STEVE WATSON
& PARTNERS

Hall Street, Bondi

BCAAssessment Report

REPORT 2008/090 R1.4

North Elevation
1:400@A3

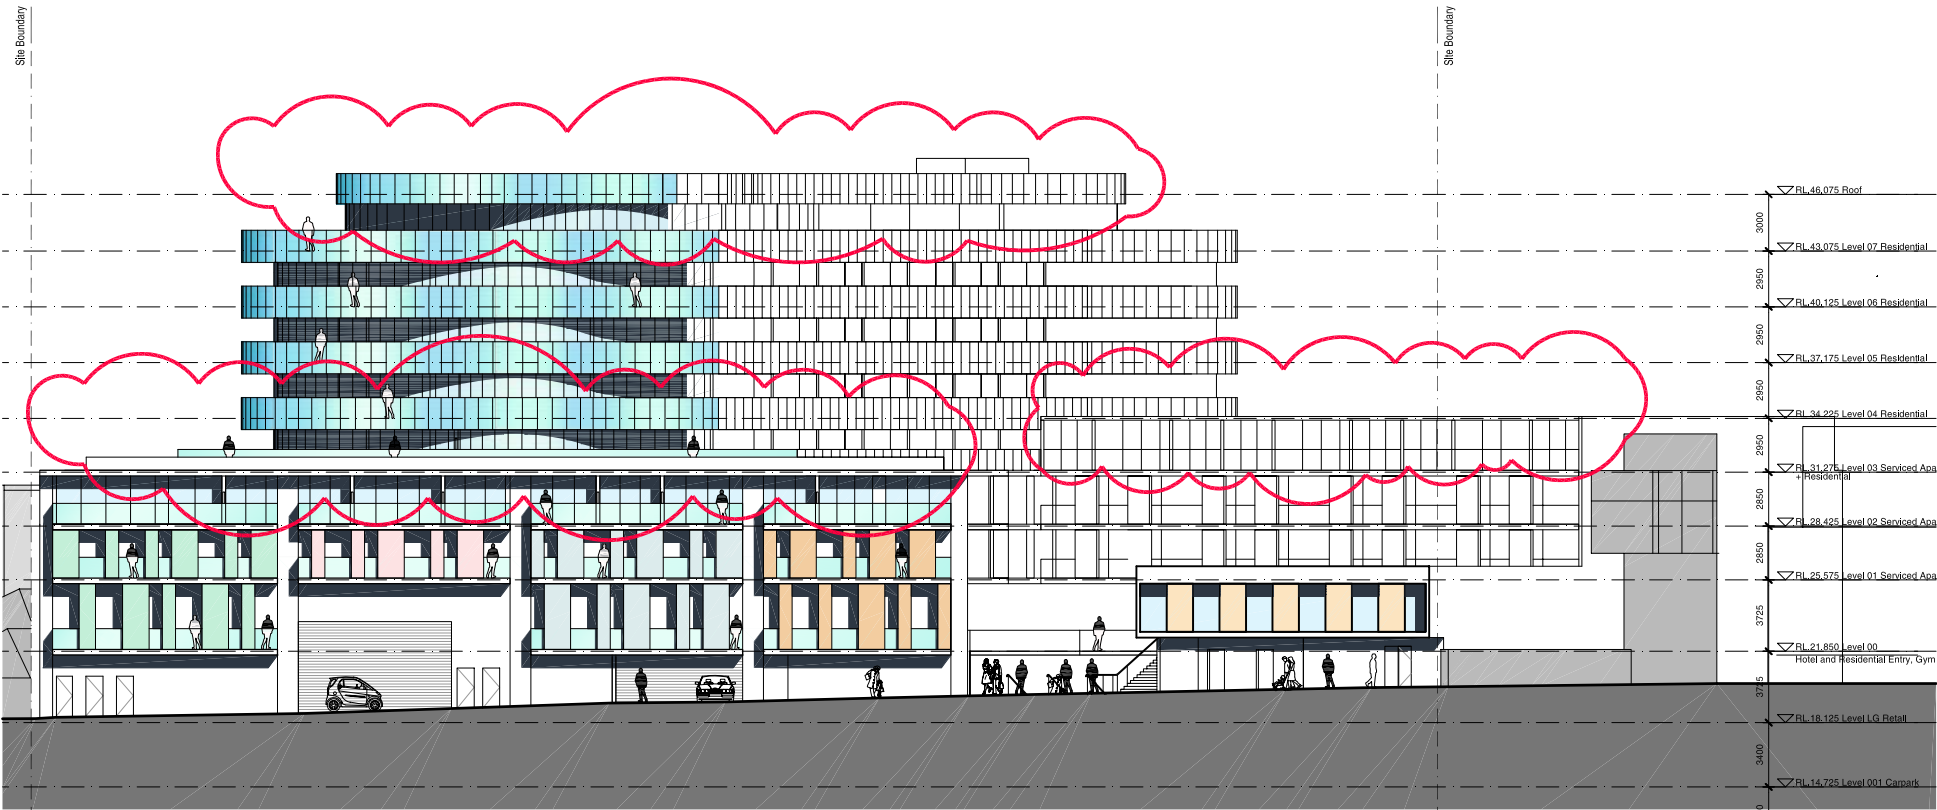
2.	C2.6	Spandrel separation has not been shown for all windows along the O'Brien & Hall Street facades, and the glazed corridor end on level 2.	Clause C2.6 requires the extension of 450mm beyond openings where horizontal spandrels are proposed. Alternatively, vertical spandrels consisting of a 900mm fire rated vertical upstand are to be provided.

Basement Carpark Level 003
1:400@A3

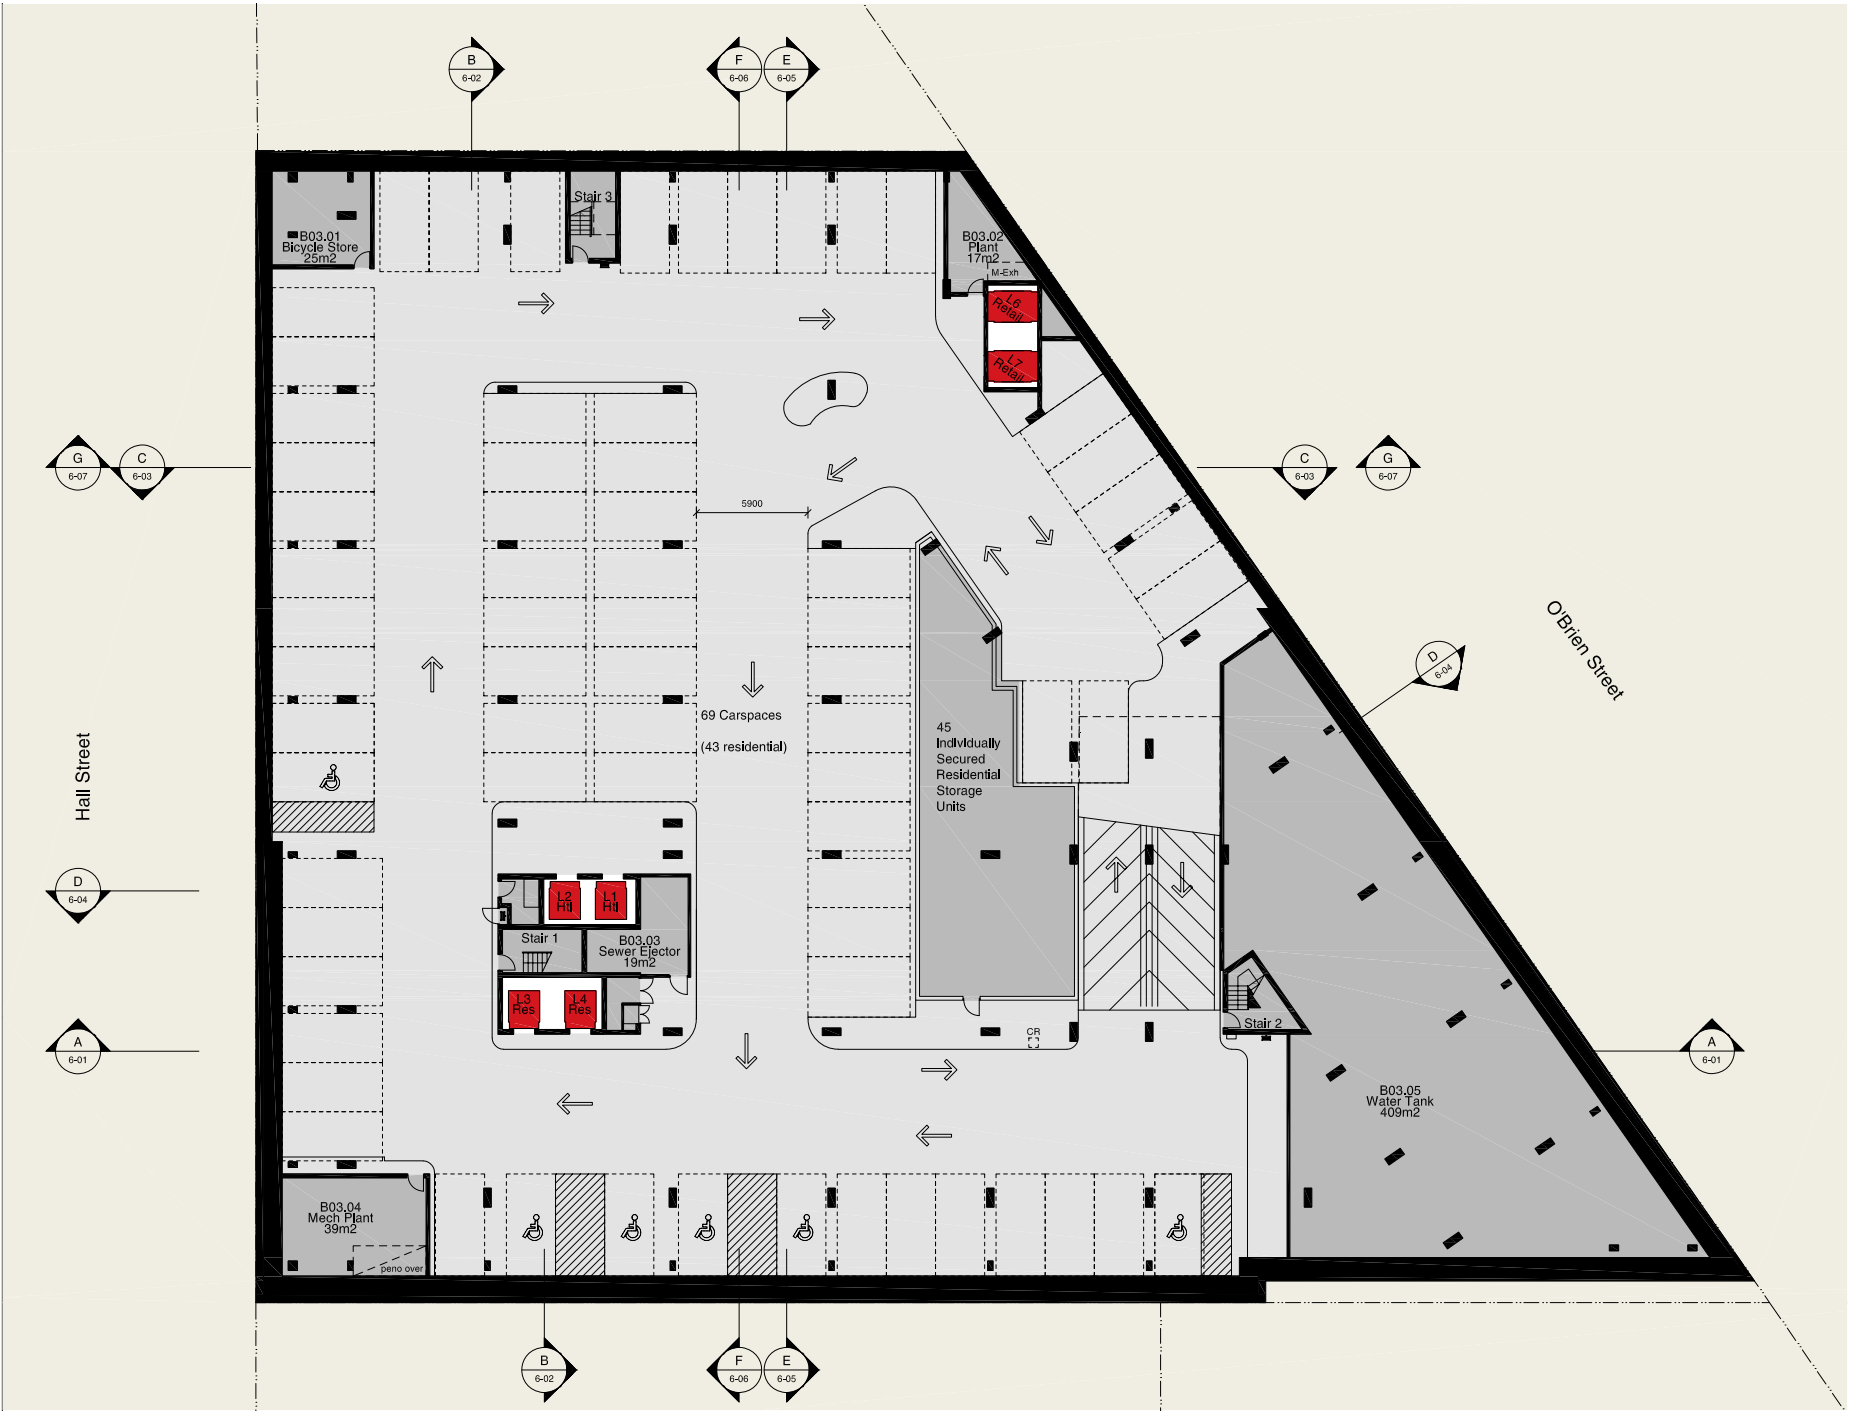
Item	Non-Compliance	DTS Clause	Description	Performance Requirement	Comments
2.	Extended travel distances	D1.4	Extended travel distances occur in the following locations: - Basement 03 – the area under the vehicle ramp is approximately 45 m to the nearest exit. - Basement 02 – The Plant room is approximately 25m to the point of choice. - Basement 02 – The southern portion exceeds 40m to the nearest exit (approx 50 m) - Basement 01 – The Garbage room is approximately 30m to the point of choice and 55 m to an exit (adjacent laundry room also affected). - Lower Ground – Retail tenancies (LG.06, LG.07, LG.08 & LG.09) facing the through site link. Travel distances may exceed 20m to the point of choice after fitout works are completed. - Levels 00-03 – The point of choice exceeds 6m from various dead-ends (up to 13m). - Level 01 – the North Eastern section has a dead end distance approaching 20 m. - The extended travel distances will be subject to a fire engineered alternative solution. Level 1 may need reconfiguration to reduce the distance.	DP4, EP2.2	Subject to fire safety engineering design.

3.	Distance between alternative exits	D1.5	- Basement 03 – Distance between exits is approximately 65 m measured through the point of choice. - Basement 02 - Distance between exits is approximately 72 m measured through the point of choice. - Basement 01 – The Switch room area is approximately 78 m between exits measured through the point of choice. - Exits 1 & 2 are located approximately 47 m apart on Levels 1, 2 & 3. Extended distances between alternative exits will be subject to a fire engineered alternative solution.	DP4, EP2.2	Subject to fire safety engineering design.

Lower Ground Floor
1:400@A3

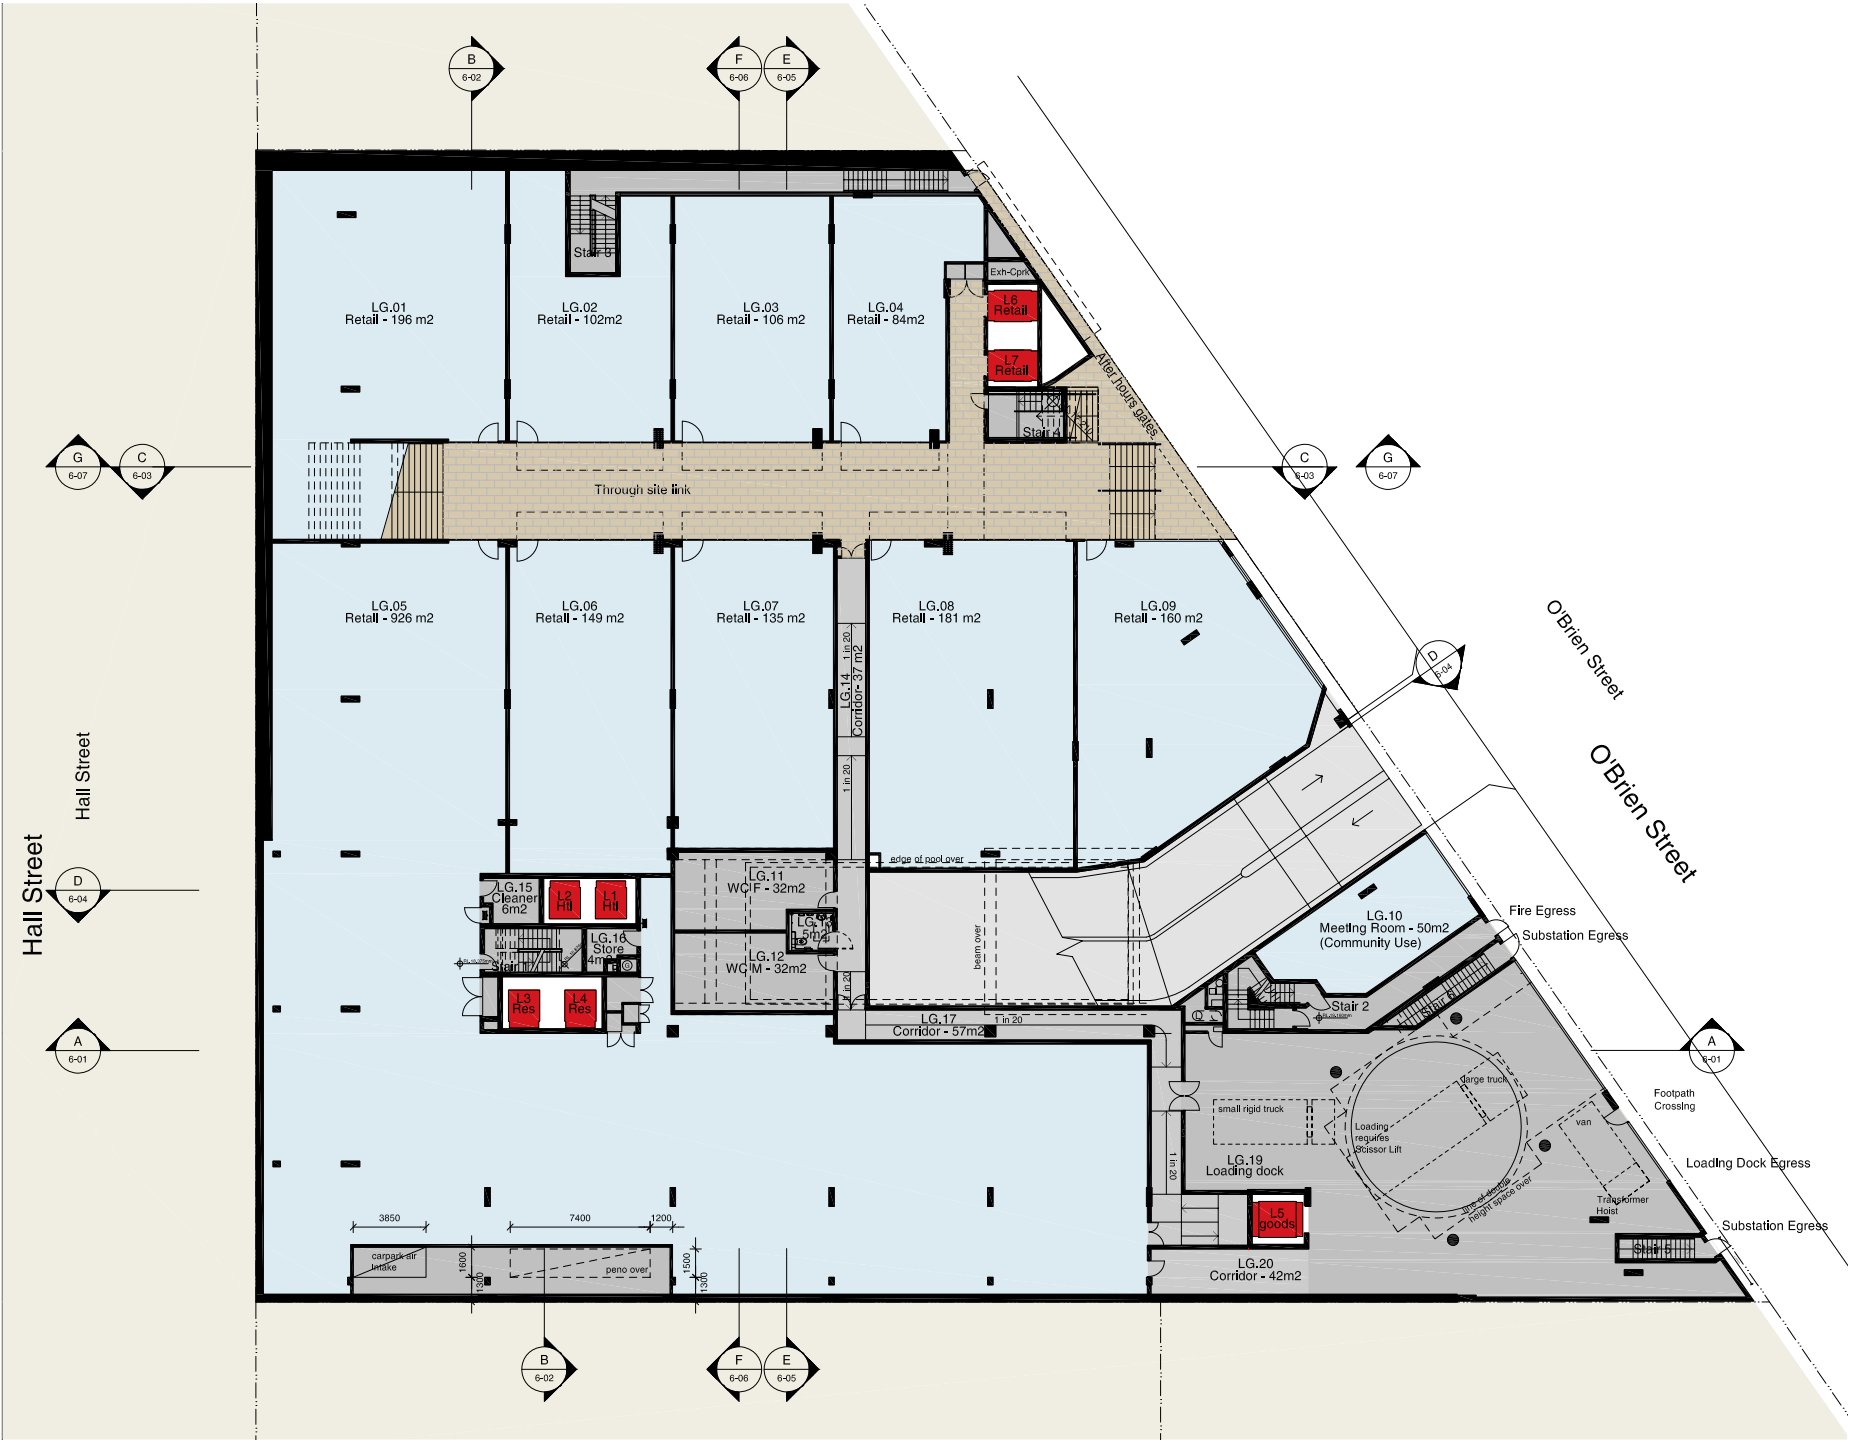
1. The toilet block on the Lower Ground Floor will be relied upon for use by the retail and restaurant staff and restaurant patrons.
2. The double doors accessing the Loading Dock from the service corridor on the Lower Ground Floor will be openable at all times in the event of an emergency and can act as a horizontal exit. The loading dock is to form a separate fire compartment.

4.	Direct access into fire-isolated exits	D1.7	Retail tenancy LG.05 opens directly into Exit 1 (Stair 1) on the Lower Ground Floor.	DP4, EP2.2	Subject to fire safety engineering design.

Item	Non-Compliance	DTS Clause	Description	Performance Requirement	Comments
6.	Discharge of fire-isolated exits	D1.7	The path of travel to the road, from the discharge point of Exit 4 (Stair 4), necessitates passing within 6m of the glazed shopfronts to retail tenancies LG.08 and LG.09. The discharge area is not open for 1/3 of the perimeter. Openable doors will be unable to comply with C3.4.	DP5, EP2.2	Subject to fire safety engineering design.
